From: Graham Evans
Sent: 05 July 2013 15:14
To: Planning.Responses
Cc: David Monk
Subject: FW: Planning Consultation on: FP/100/13/

APPLICATION FP/100/13/

Description of Works: Application for Variation of Condition 40 imposed under planning consent FP/92/04 - relating to operating hours.

Description of Works: Application for Variation of Condition 40 imposed under planning consent FP/92/04 to allow for the construction of the relief road viaduct during the twenty four hour period between 1st October 2014 until 28th February 2015.

Project: Bognor Relief Road Viaduct	Description: Site Location and Nearest Residential Properties		 24Acoustics
DWG No: Figure 1	Scale: N.T.S.	Rev: A	
Date: March 2013	Drawn By: RP	Job No: R1401

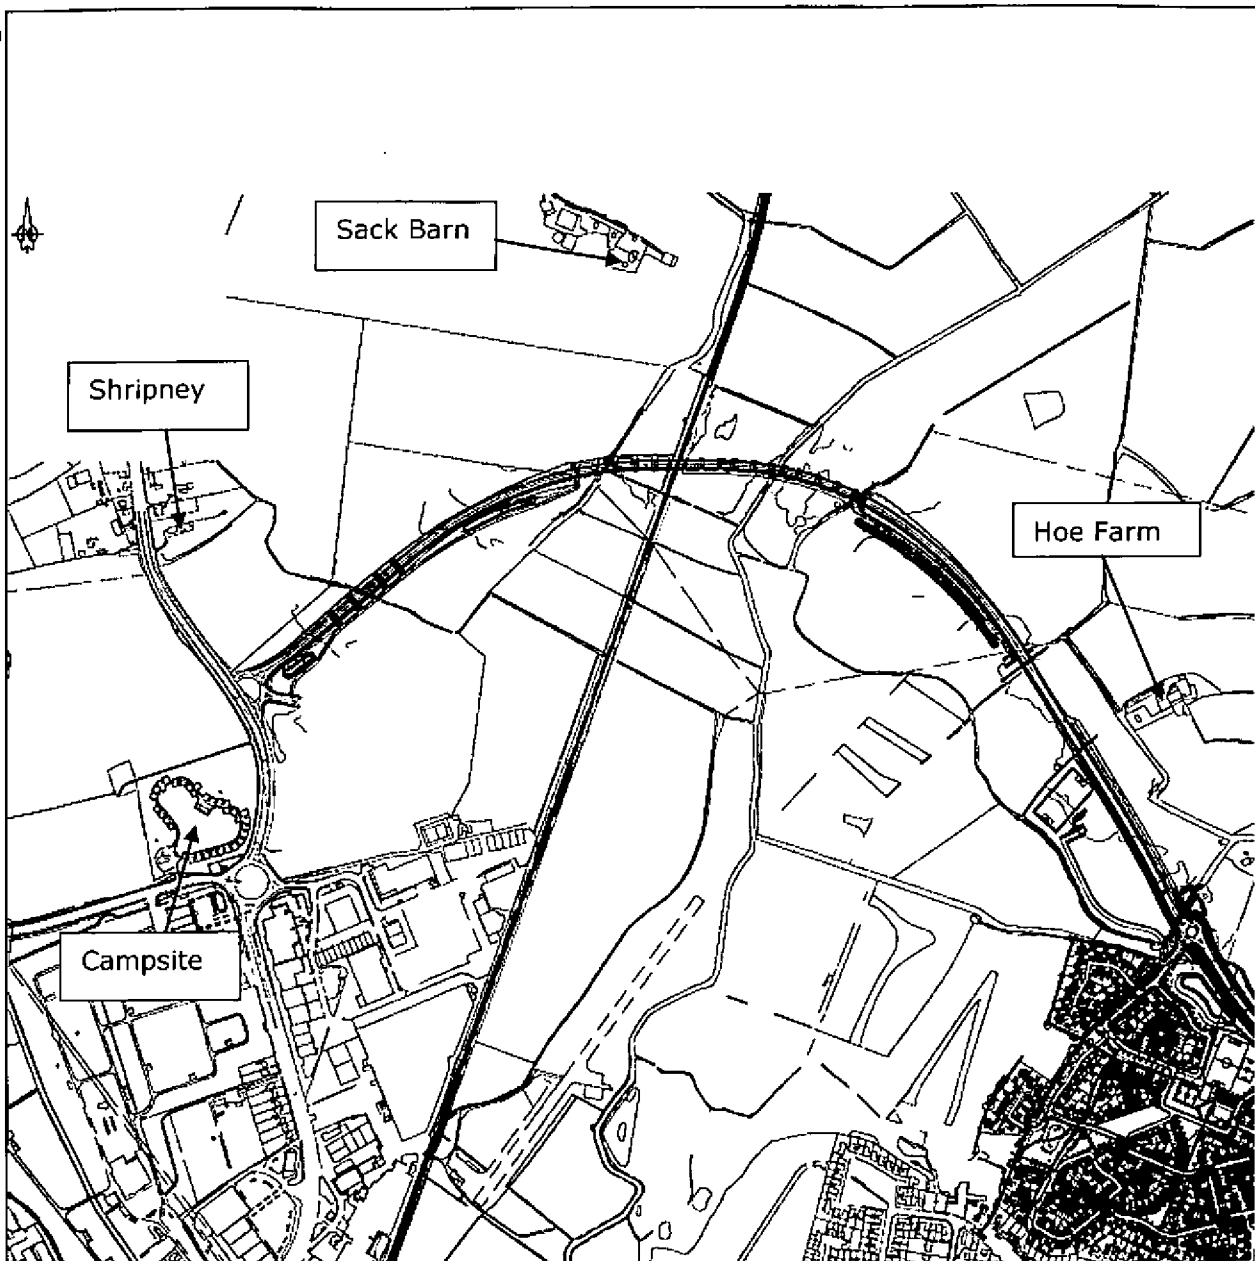
A limited number of residents (principally in the vicinity of Sack Barn) will potentially be significantly affected by night time works, the offer of temporary hotel accommodation to these residents during the weekend possessions should be considered. Further noise assessment once works have commenced may inform this decision.
